Project: I5719B – U5800 Design Build

Subject: Hydraulics CP4B Meeting - Minutes

Date: Wednesday, April 15, 2026

STREAM SBO
SITE 14

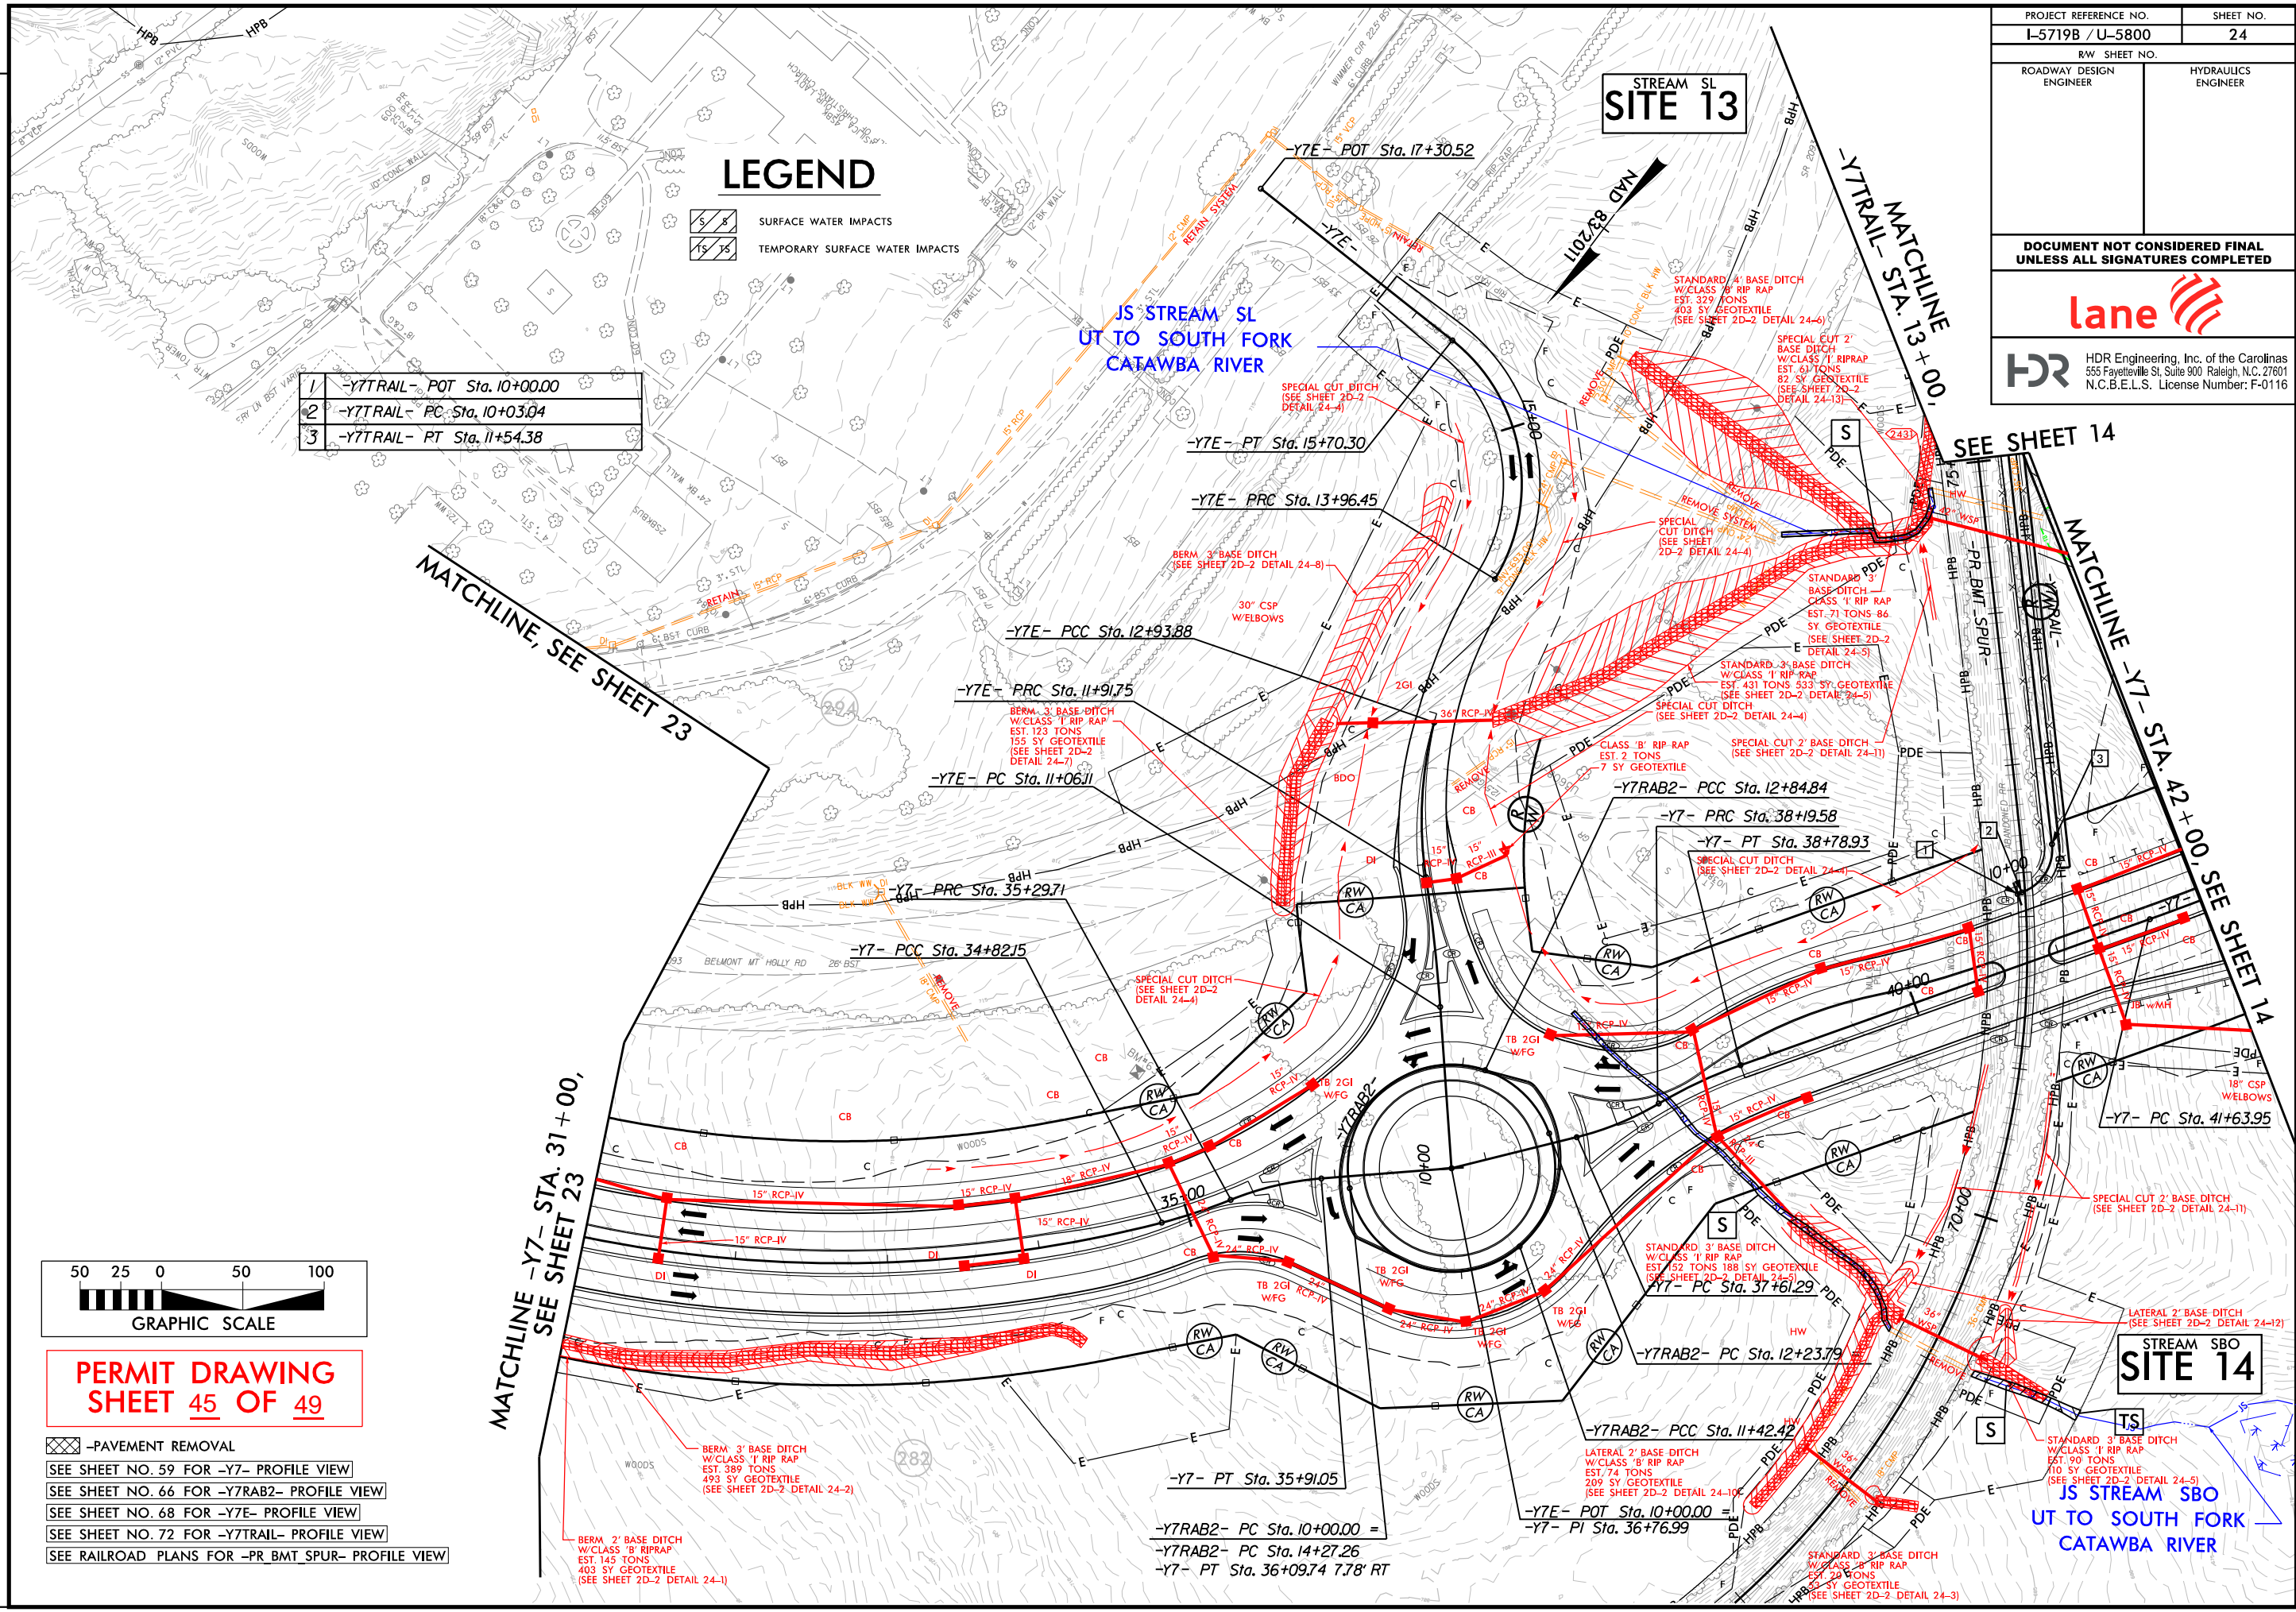
- **Bill Barrett – Stream might be SBO instead of SBP.**
- **Crystal Amschler – No blue line connecting stream to outlet?**
- **Bill Barrett – might be small wetland in between**

- **James Rice – will evaluate and update plans.**

PROFILE ALONG 4'X6' RCBC – SITE #15

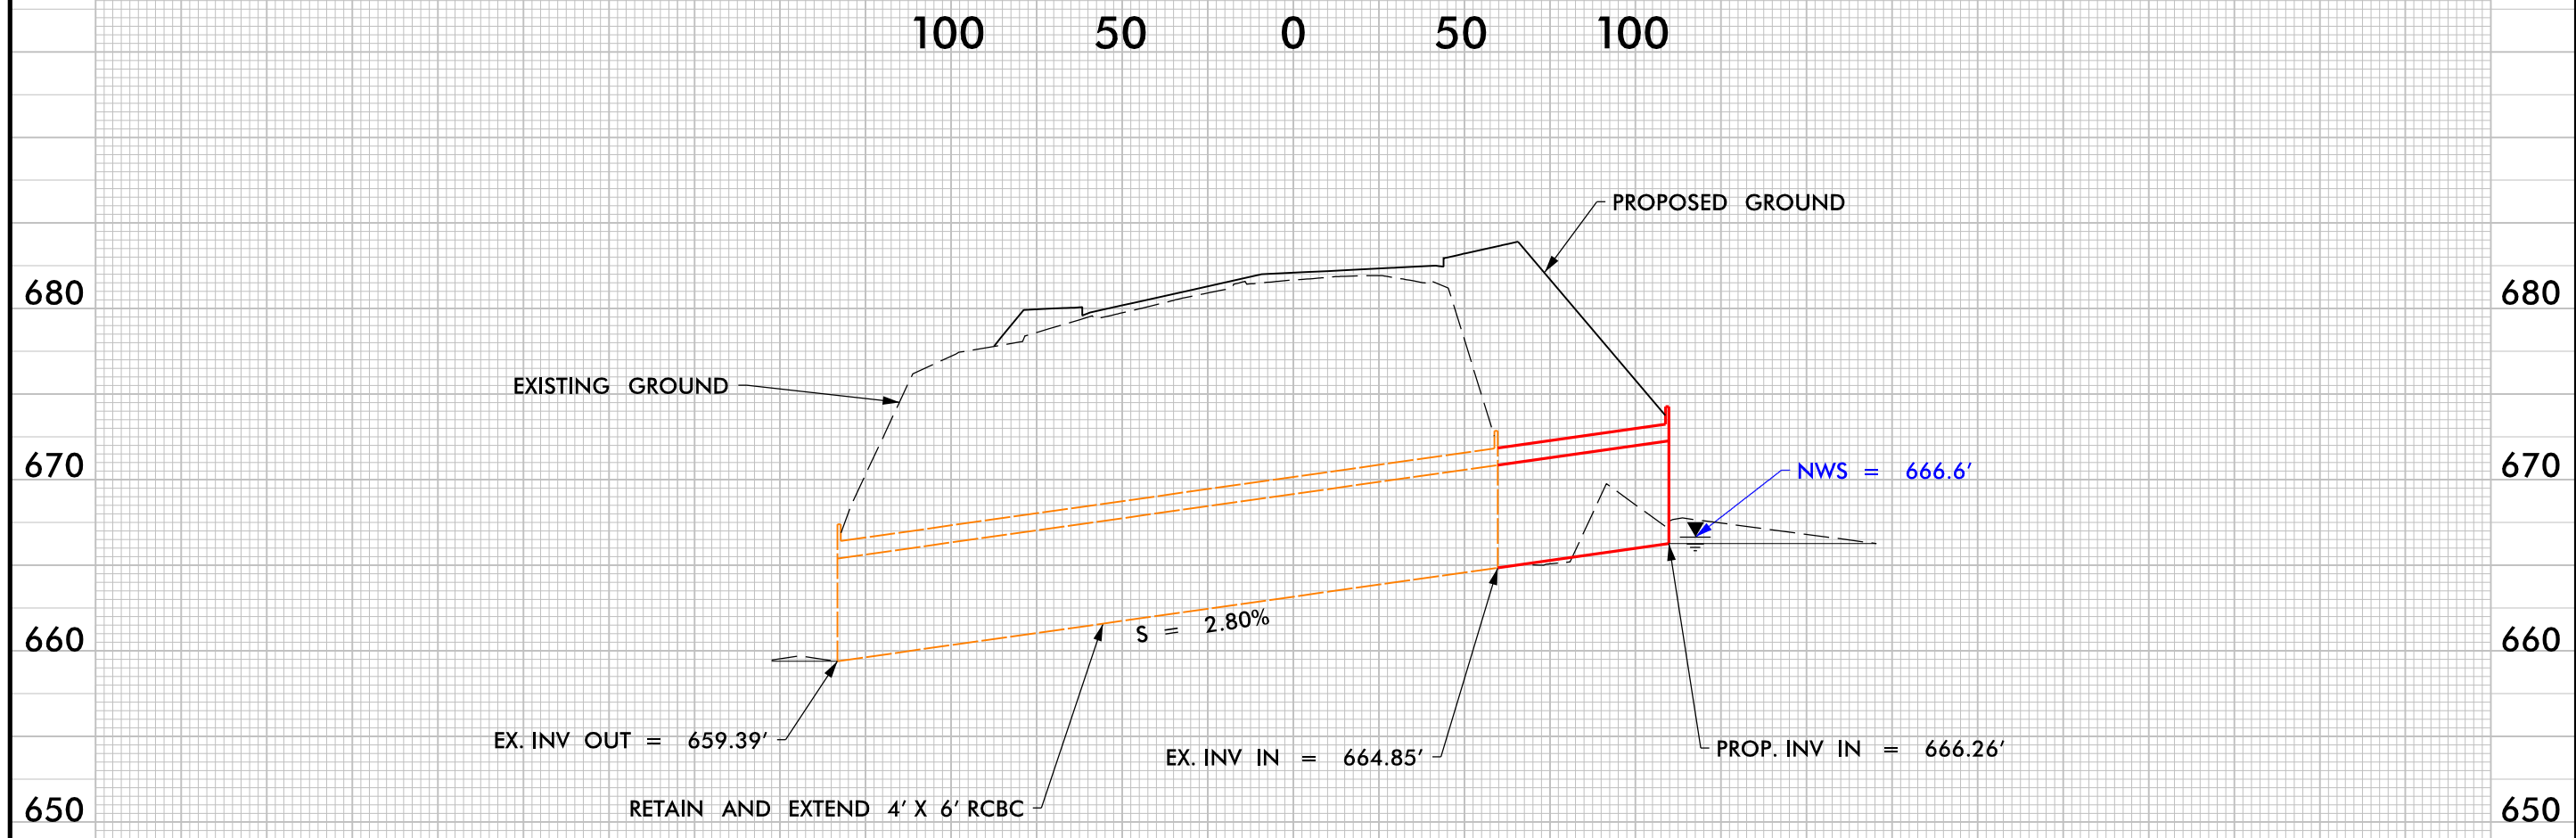
- Stream SCF – UT to UT at Belmont Abbey College
  - Existing 4'X6' RCBC
  - Extending the upstream end approximately 50ft
  - Existing box culvert has a partial concrete sill running the length of the culvert ~6in in height, maintaining daily flow. Inlet extension would include extending this sill.

- Upstream
    - Utilizing Bank Stabilization approximately 25'
    - No rip rap in the bed of the stream
  - Downstream
    - Utilizing Bank Stabilization approximately 25'

- No rip rap in the bed of the stream
- Lack of positive drainage due to heavy sedimentation at the culvert outlet. Would the Agencies like bank stabilization be changed to channel improvements to restore positive flow?

- **Dave McHenry – will the box culvert extension keep the existing grade or will it be flattened out. We will have that sheet in the 4C plans.**
- **Dave McHenry asked why there is a concrete shelf in the box. Tom shared a photo of the outlet in the meeting. They haven't gotten into the details and can reproduce it if needed? Dave would like to keep the shelf. Lane stated they would prefer to keep same condition for constructability.**

*Action Item: Provide location for the Division to look into the history of the culvert shelf.*

*Email from Larry Carpenter (NCDOT Division) on 4/28/26  
It appears the slot was formed in the culvert during construction (chamfered edge) and I do not think it would be for a utility because its just not big enough.*
